From: Amanda Jenkins <slincsfens@lincstrust.co.uk>
Sent: 26 January 2022 11:32
To: Buttery, Lucy
Cc: _planningadvice
Subject: H06-0960-21, Hydroponics facility at Norfolk House Farm, Main Rd, Gedney Drove End.

Observations on application H06-0960-21 – 30ha of land at Gedney Drove end.

Figure 32 Southern Landscaping Scheme

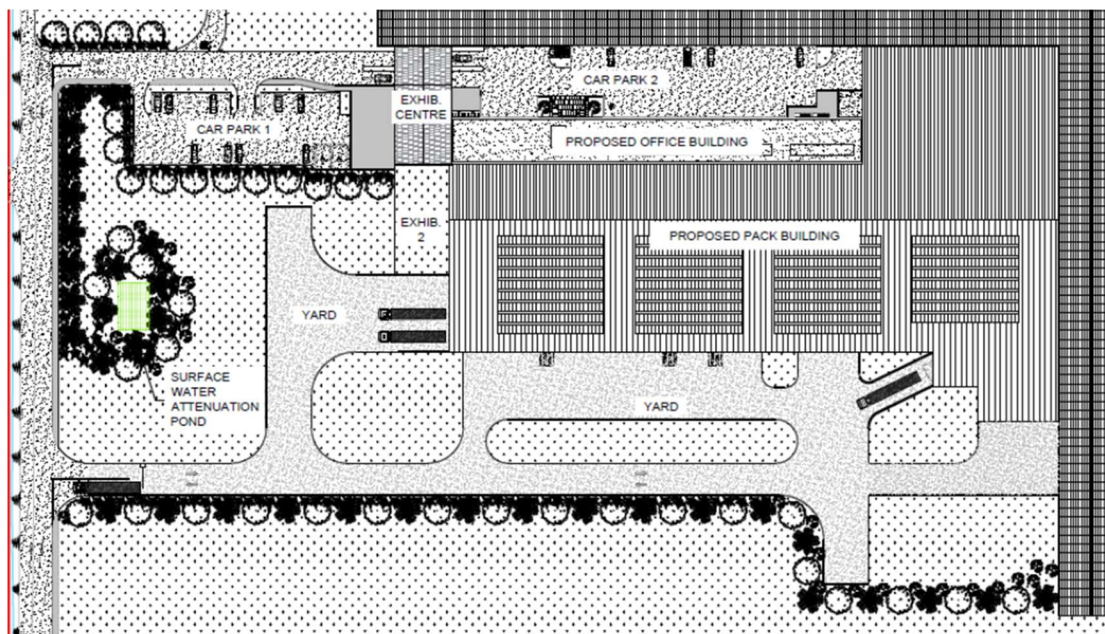
- Landscape plan suggests that new hedging will be cherry laurel, which is a non-native species. Native species hedging of known value for wildlife should be planted. These should complement the existing woodland and hedgerow features around the site. See Woodland Trust for species options.

- Ash trees are suggested. This isn't a sustainable choice given the prevalence of Ash Die Back contact the Forestry Commission or Woodland Trust for advice. Any trees planted should complement the native species woodland to the north and around the development site. They should be native and of known value for wildlife and sourced from a tree nursery that can guarantee local provenance.
